Application no: 22/01683/F

Location: Unit 7, Oxford Technology Park, Technology Drive, Kidlington, OX5 1GN

Lead Local Flood Authority

Objection

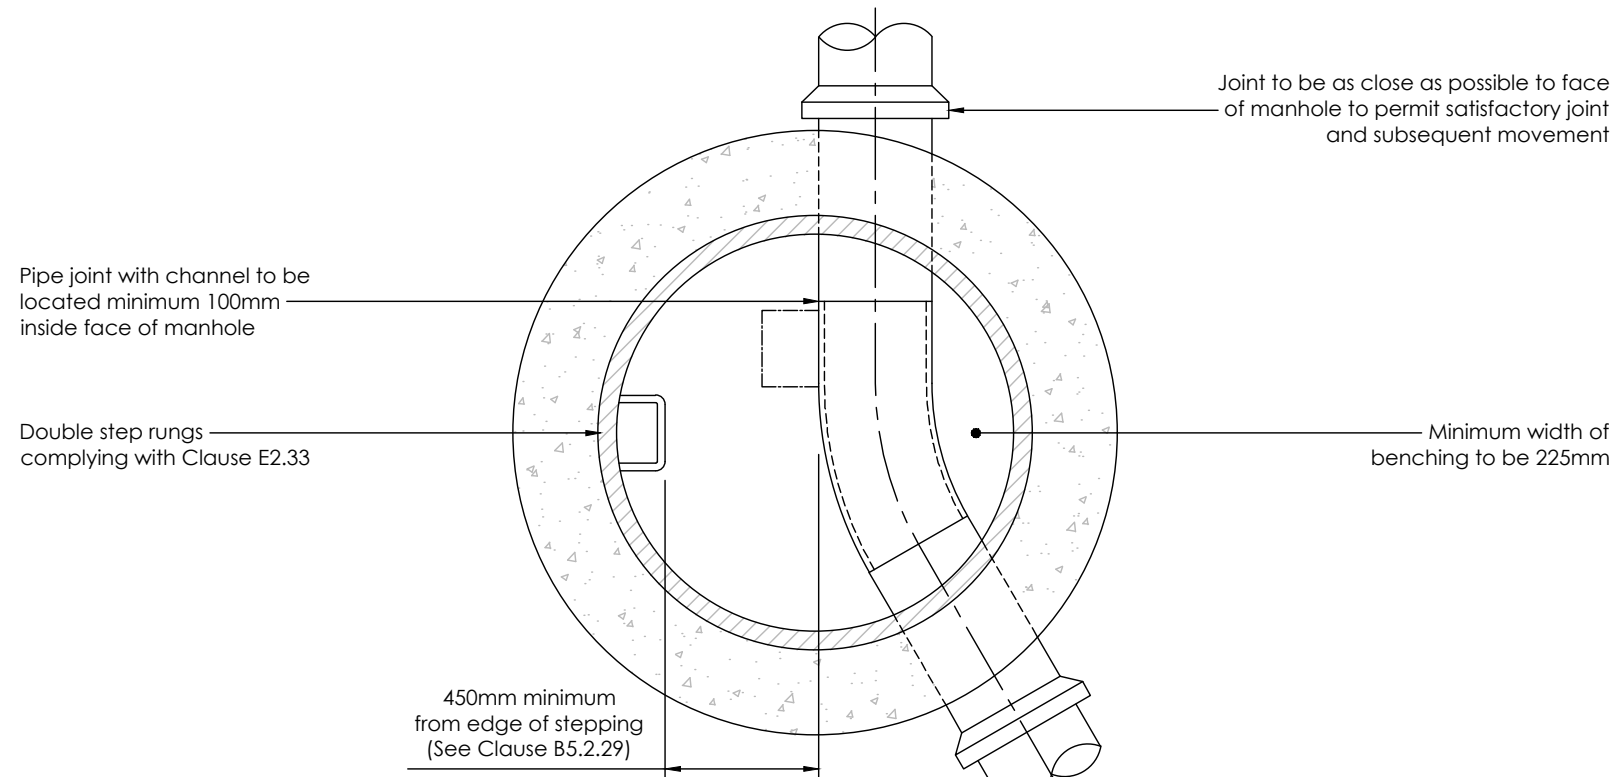
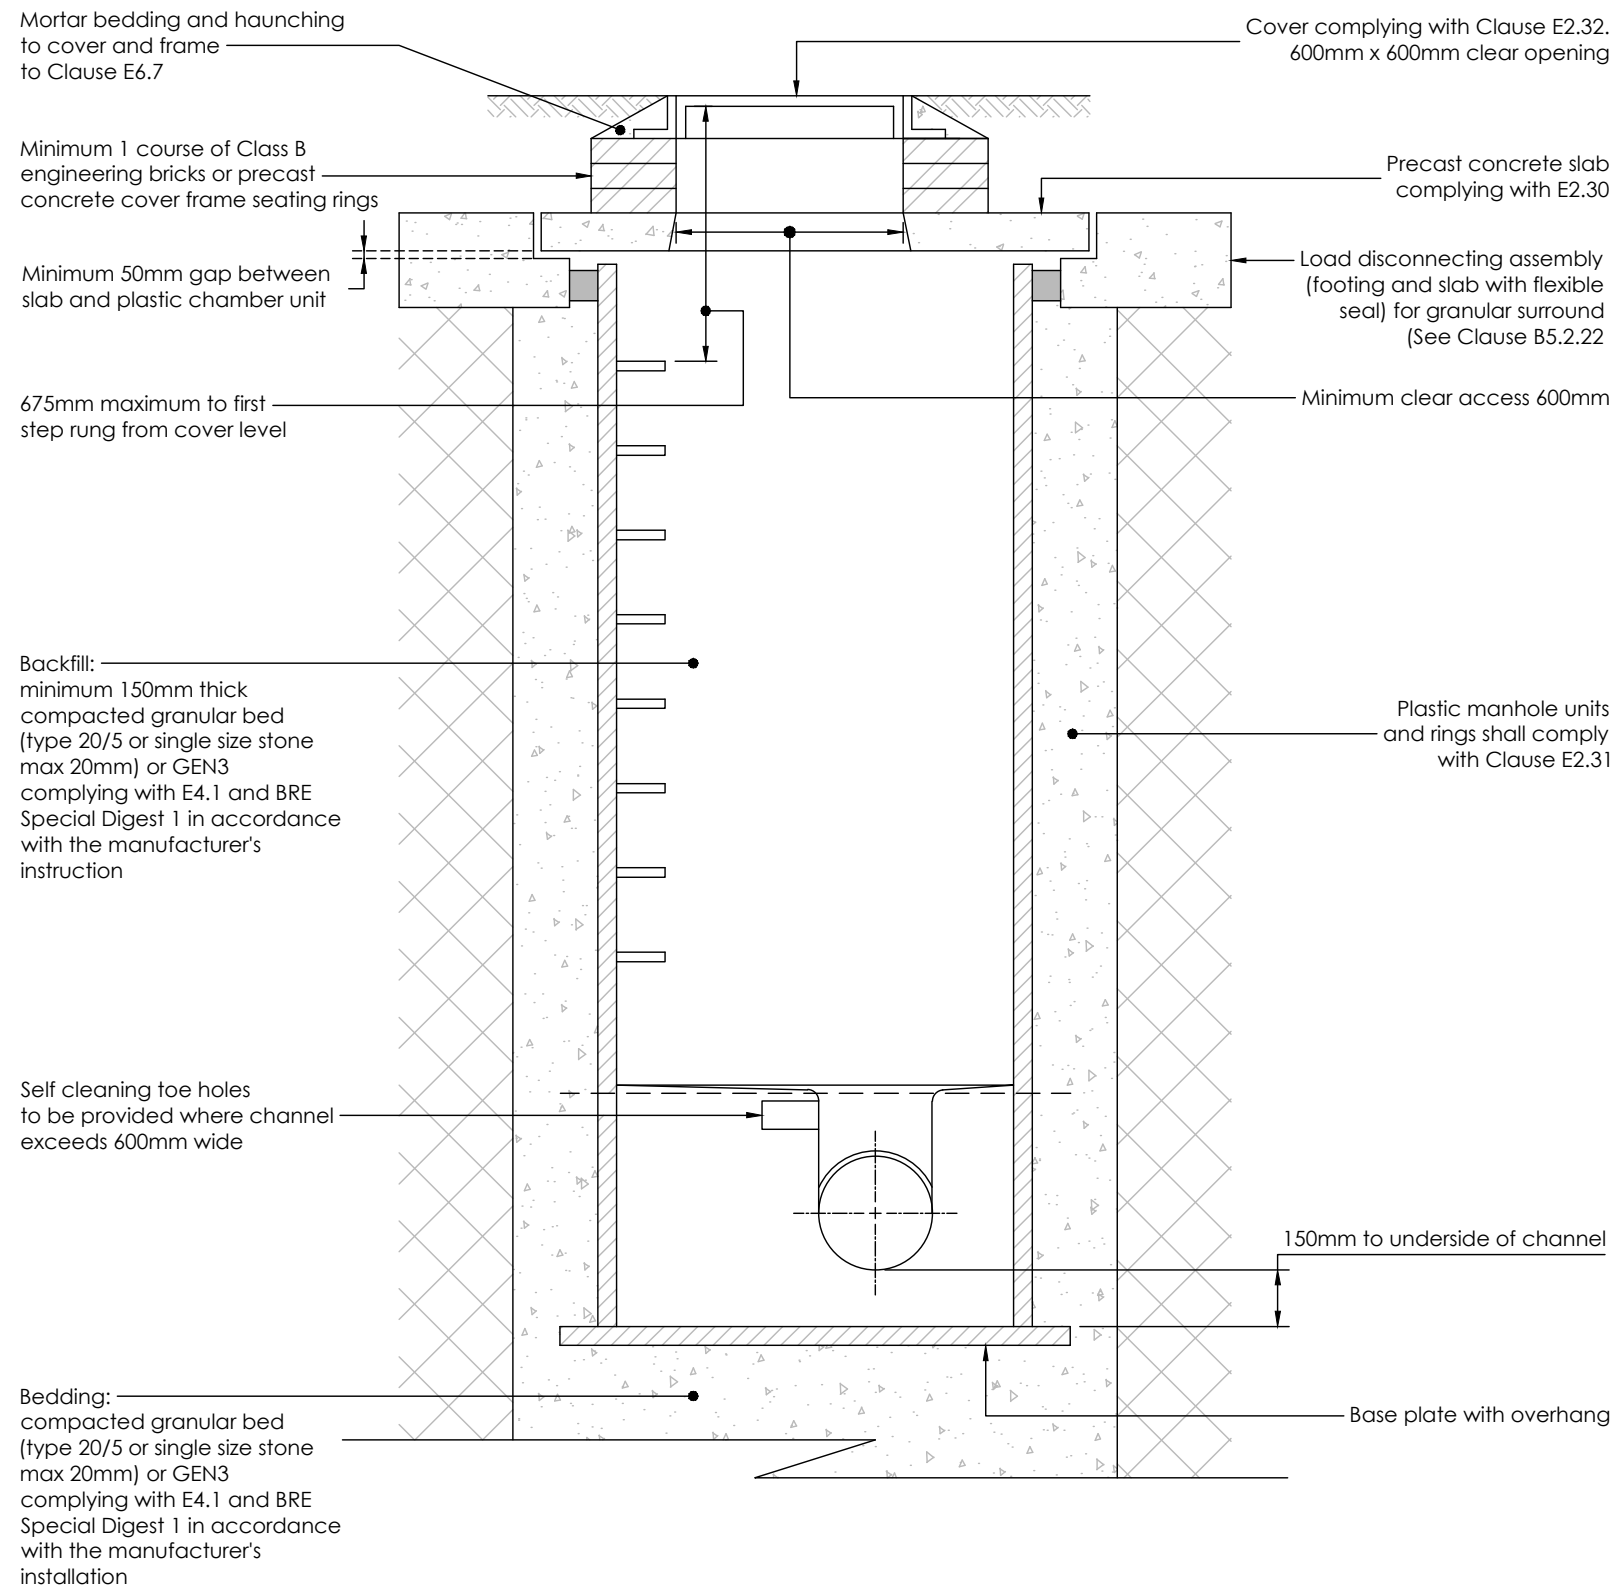
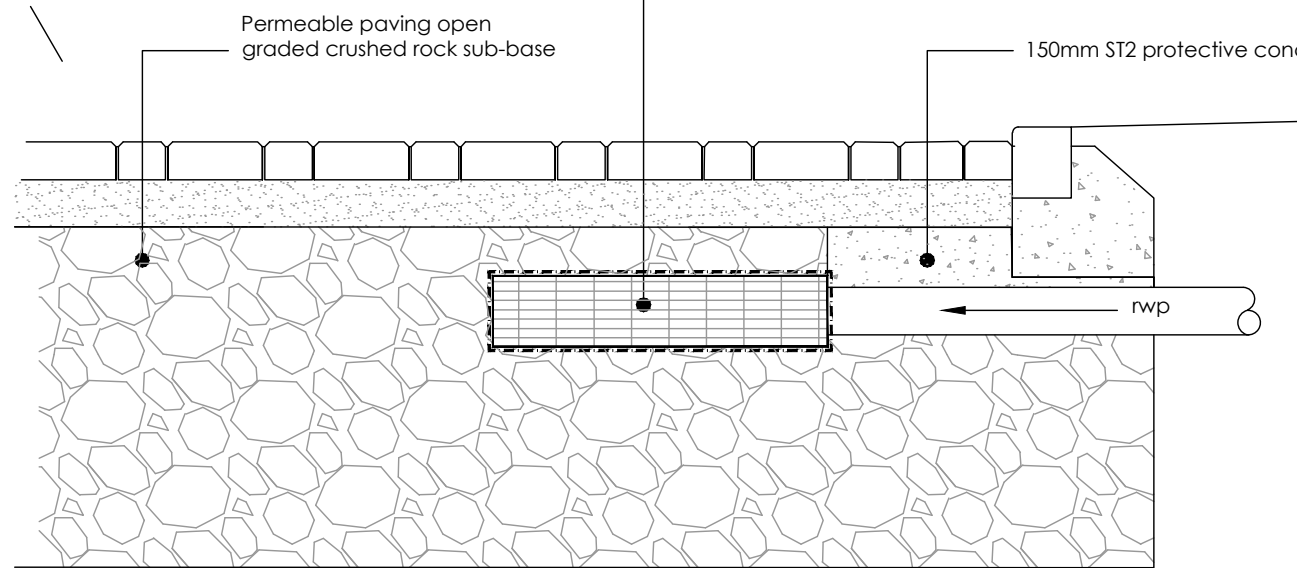
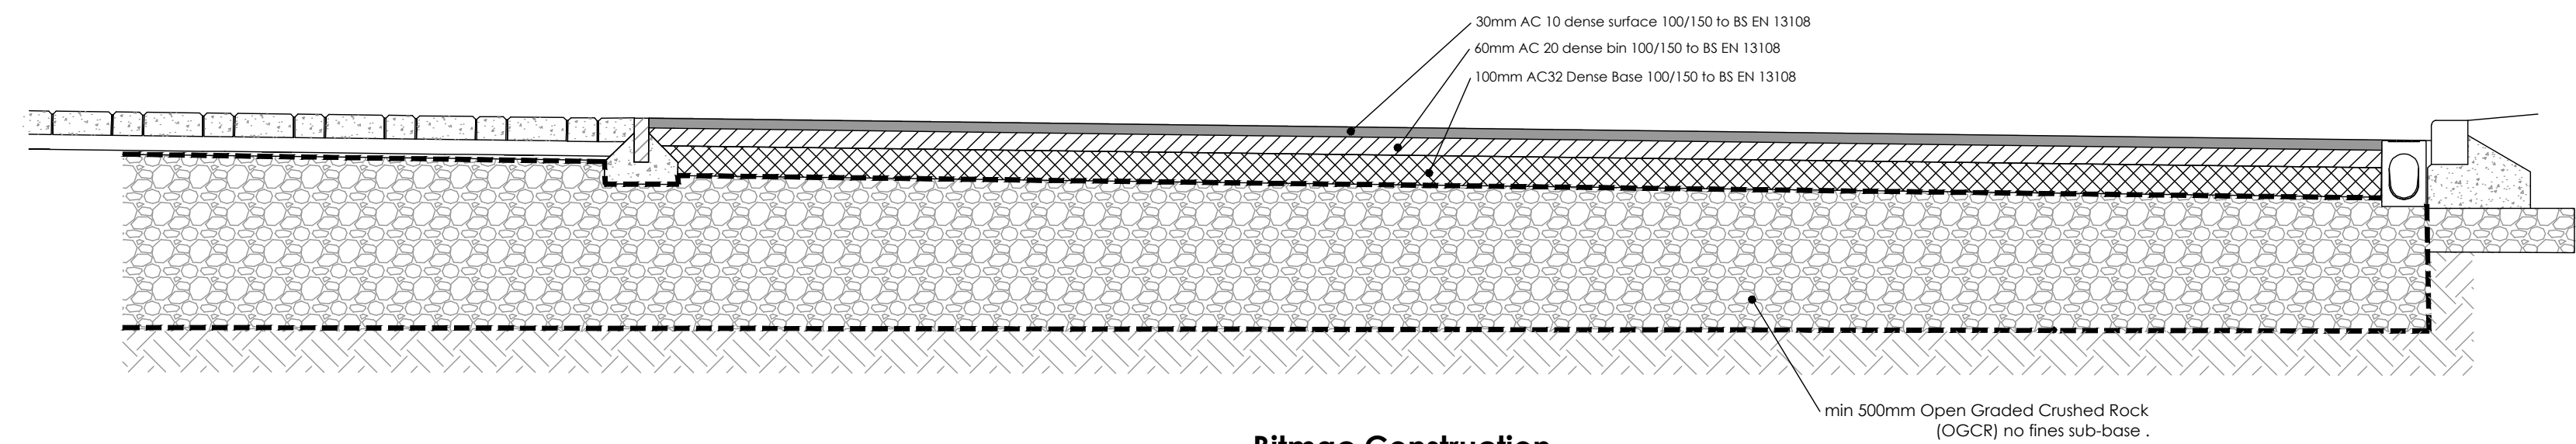
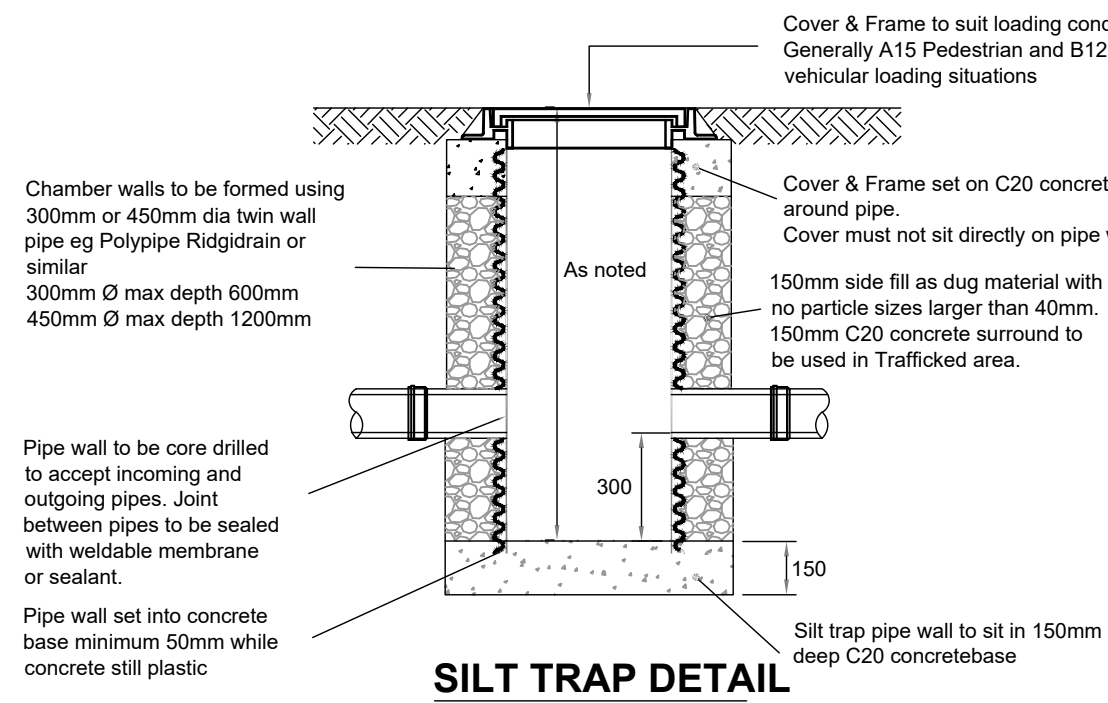
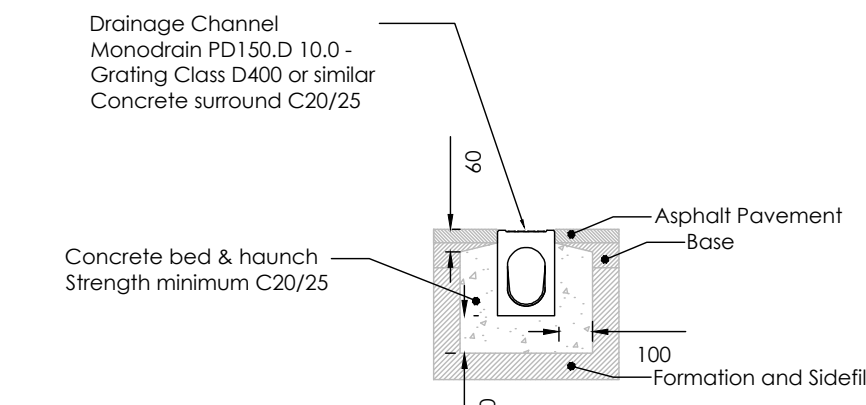
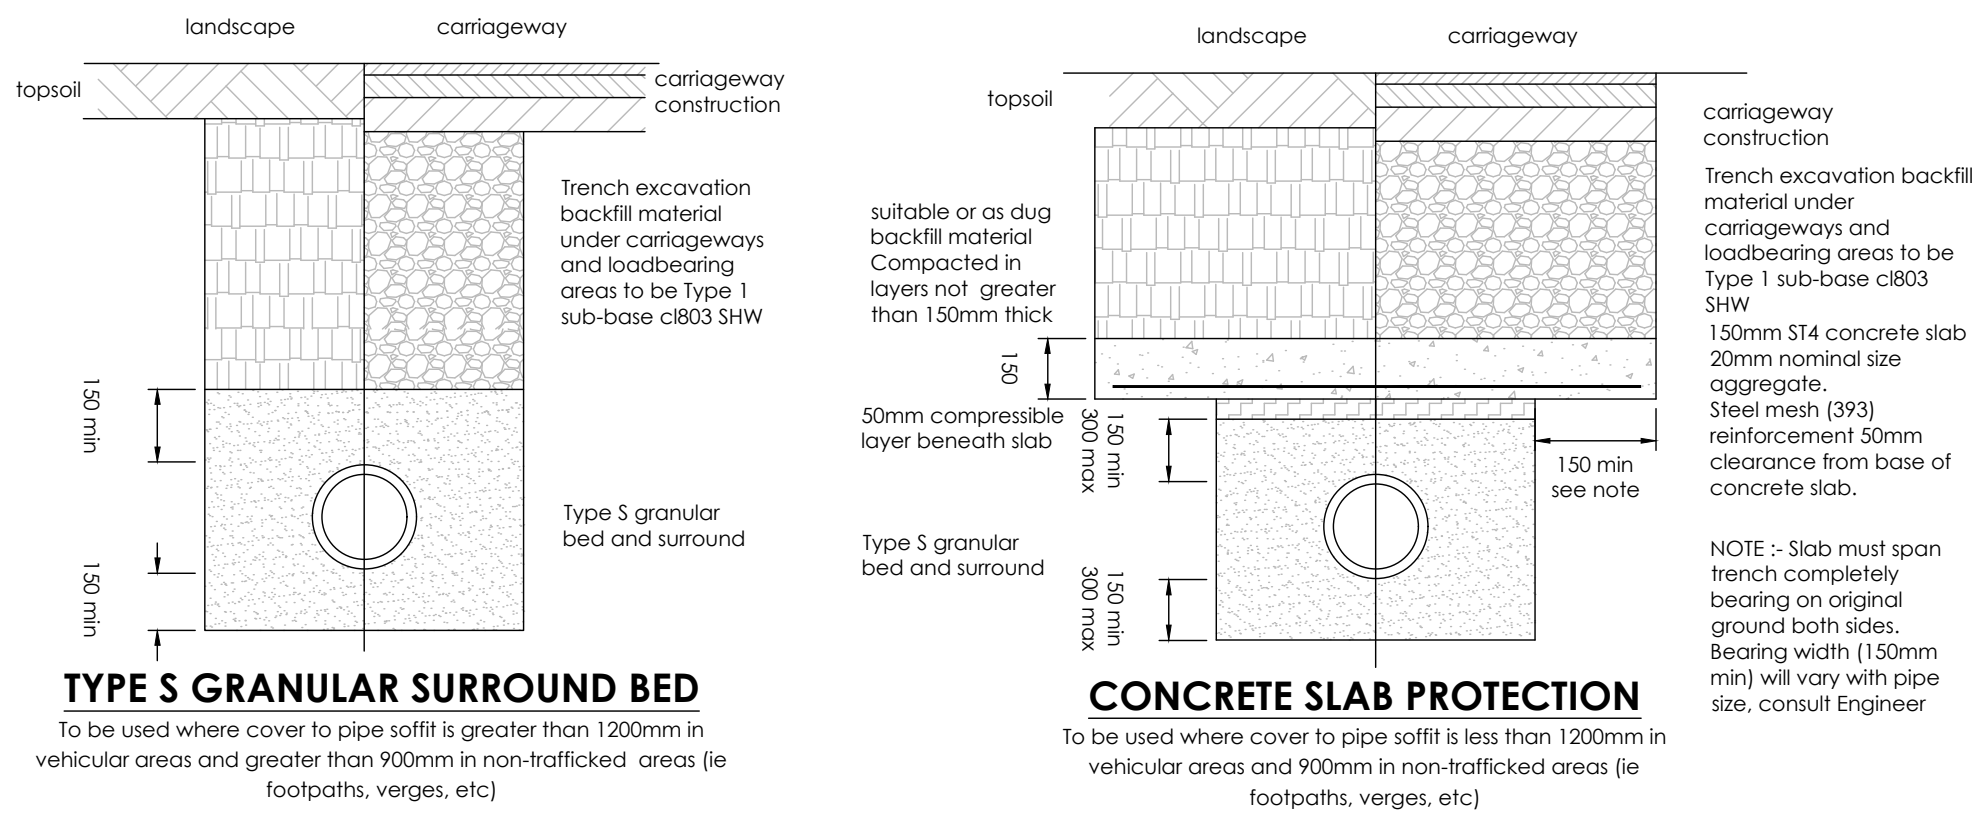
Provide SuDS construction details.
